**RESPONSE TO DEPARTMENT OF PLANNING & OTHER REFERRAL AGENCIES (TRAFFIC & PARKING COMMENTS)**

We provide herein our response to comments raised by the New South Wales Department of Planning and other relevant Agencies. Our responses relate specifically to traffic, transport and car parking comments.

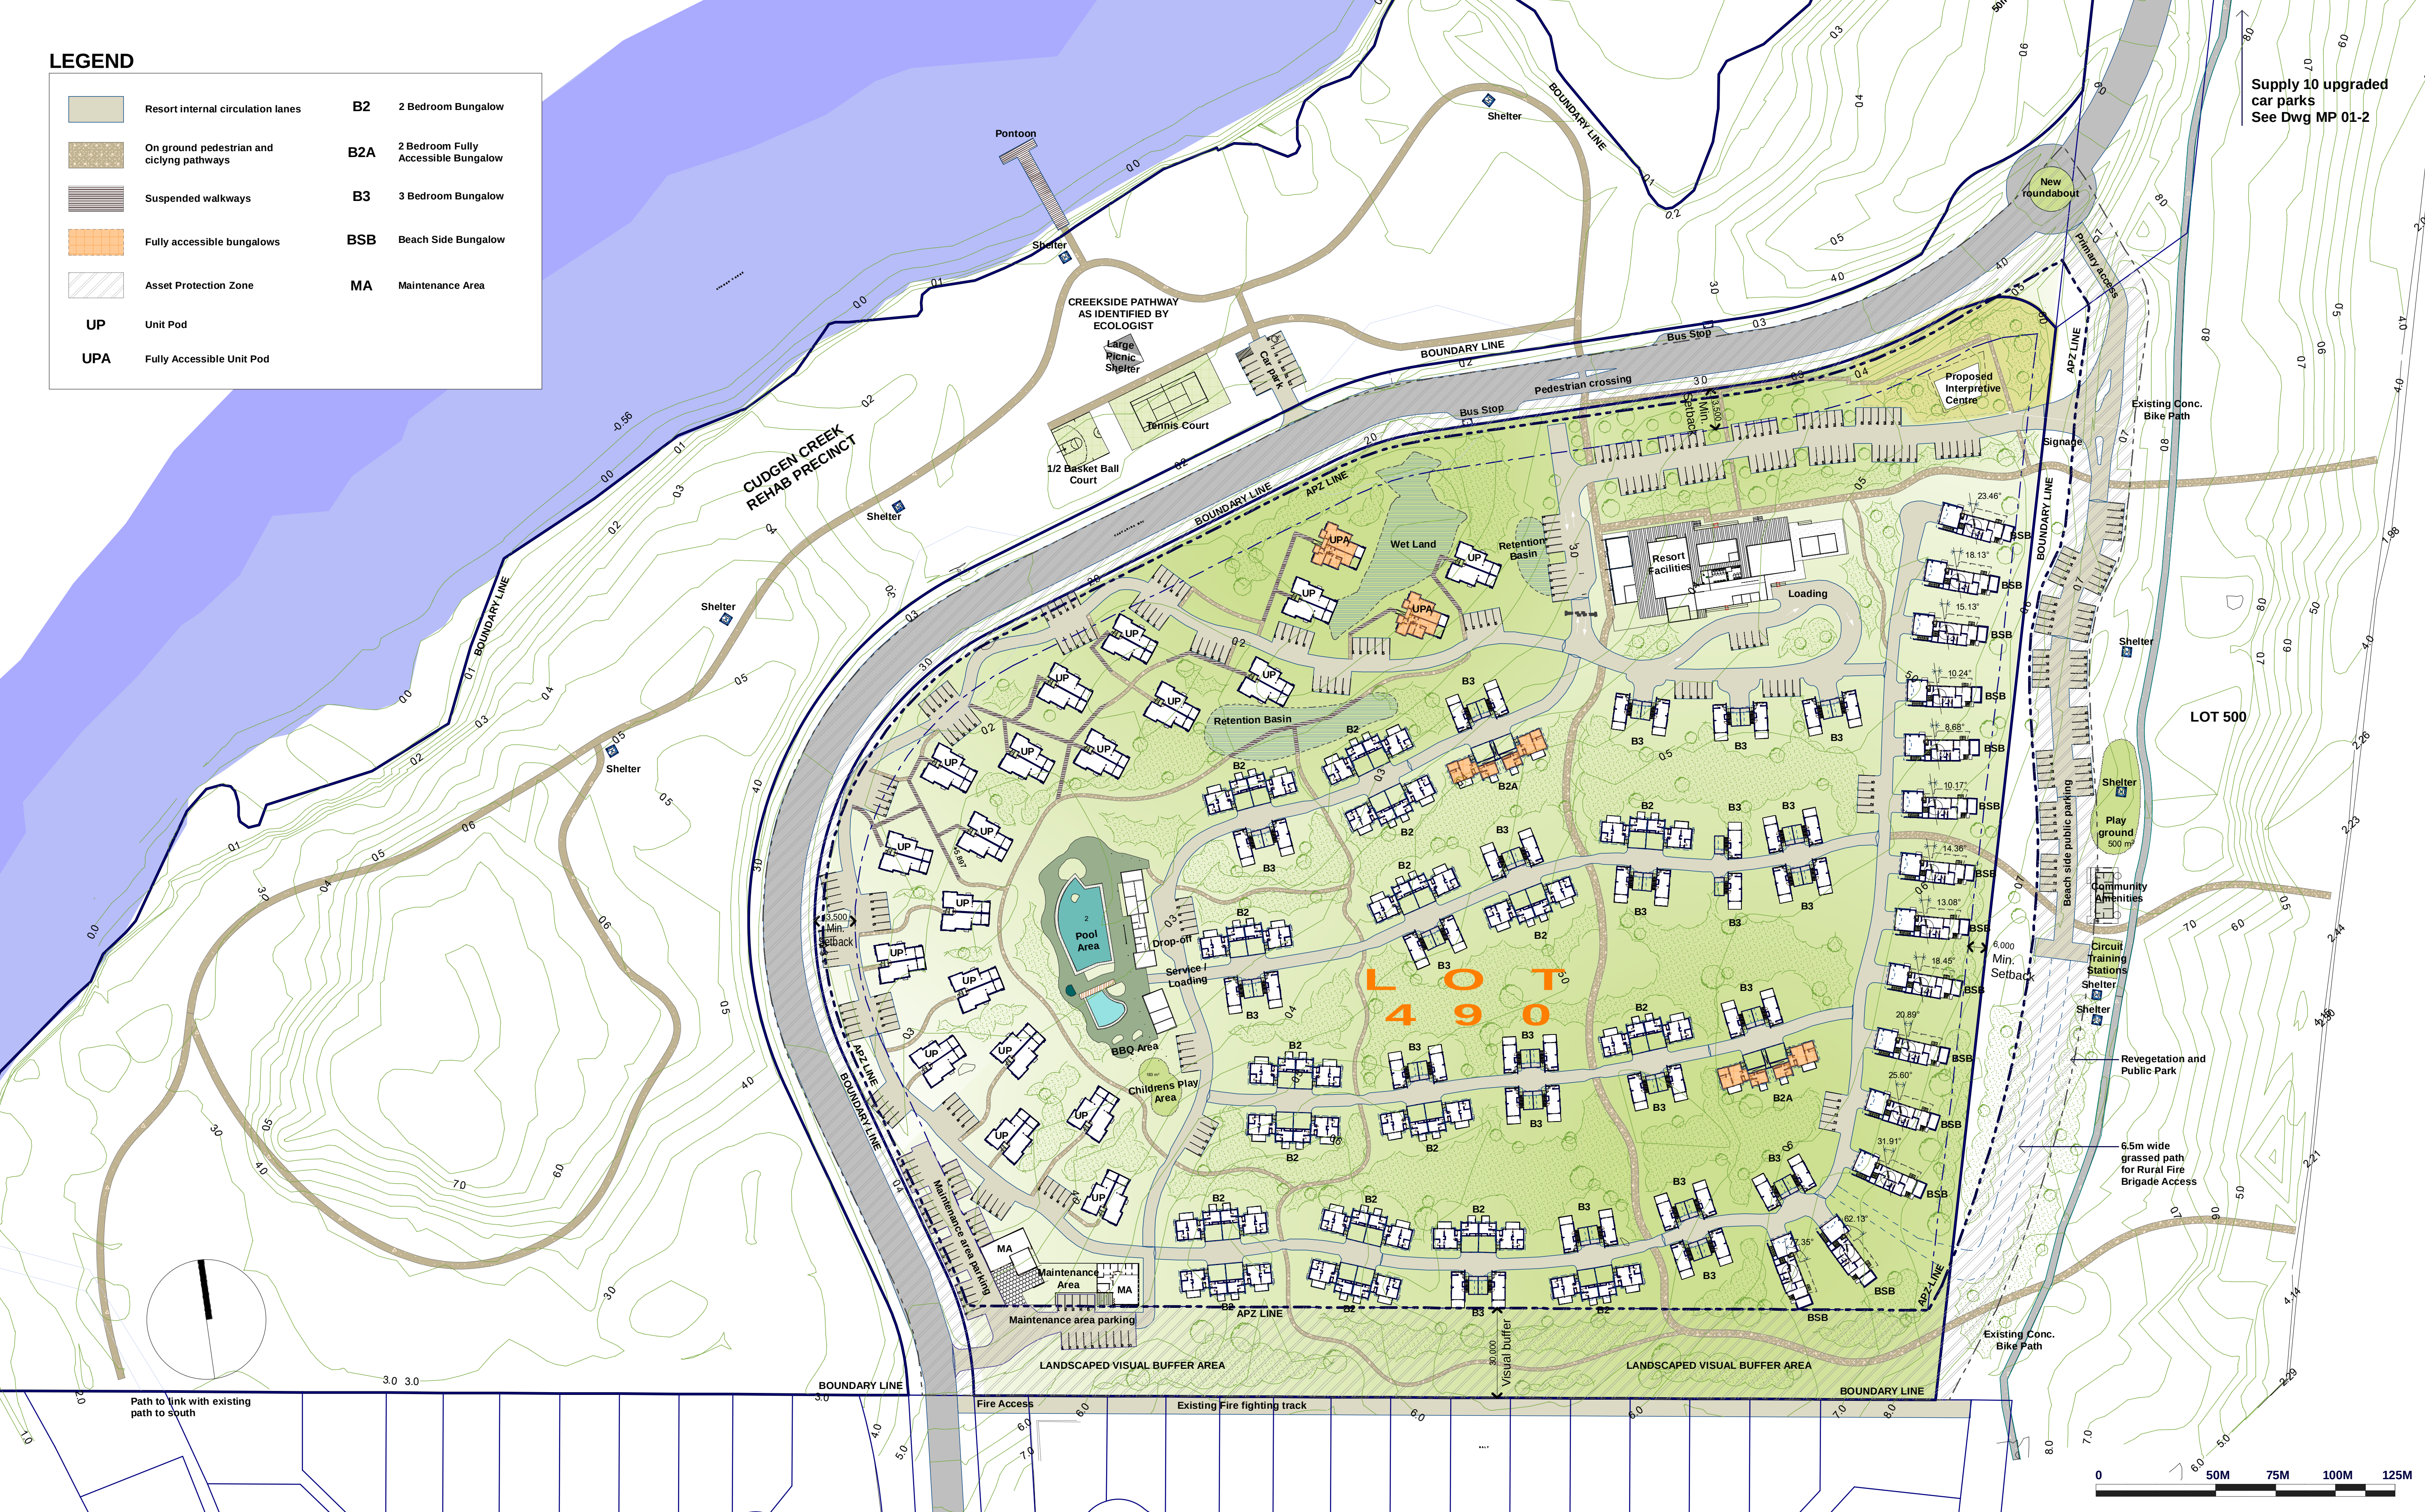
- Internal road widths cannot cater for right angle parking as shown on the proposal plans. A 6.0m minimum aisle/road width is required (refer AS2890.1 Off Street Parking Code). This has been identified in the traffic report but not shown on the proposal plans.

- The majority of the proposed internal roads do not connect to the proposed primary access and roundabout on Casuarina Way. The internal road network requires revision. The connection of the internal road network with the maintenance area access should be deleted to prohibit general development traffic using the maintenance area access from Casuarina Way.

- The cycleway near the pedestrian refuge is to be extended to the east (towards the beach) external to the resort via road reserve. Another pedestrian crossing of Casuarina Way, possibly integrating with a roundabout approach island, should be considered which connects with the existing coastal cycleway.

- The existing coastal cycleway is shown splitting the proposed northern car park area. This requires clarification.

The widths of internal circulation roads are generally less than 6.0m, with the exception of those sections adjacent to dedicated car parking areas where the aisle width has been increased to a minimum of 6.2m. This will be further detailed at the project's construction certificate approval phase (i.e. operational works phase) within detailed design drawings.

The internal circulation roads do connect to the Primary Access and roundabout on Casuarina Way (see Master Plan as Attachment B). Within the site there only two control points as follows:

- A "boom gate" system located within the circulation road adjacent to the western side of the Resort Facilities building. This gate system will prohibit the movement of non-resort traffic into and out of the resort's accommodation areas.
- A "boom gate" system located between the Resort's Maintenance Area and the accommodation areas. This gate system will only be used by maintenance vehicles and will prohibit the movement of general traffic (i.e. both Resort guest and general public) through this location of the Resort.

The Master Plan (see Attachment B) has been amended to incorporate these comments.

The Master Plan (see Attachment B) has been amended to incorporate these comments.
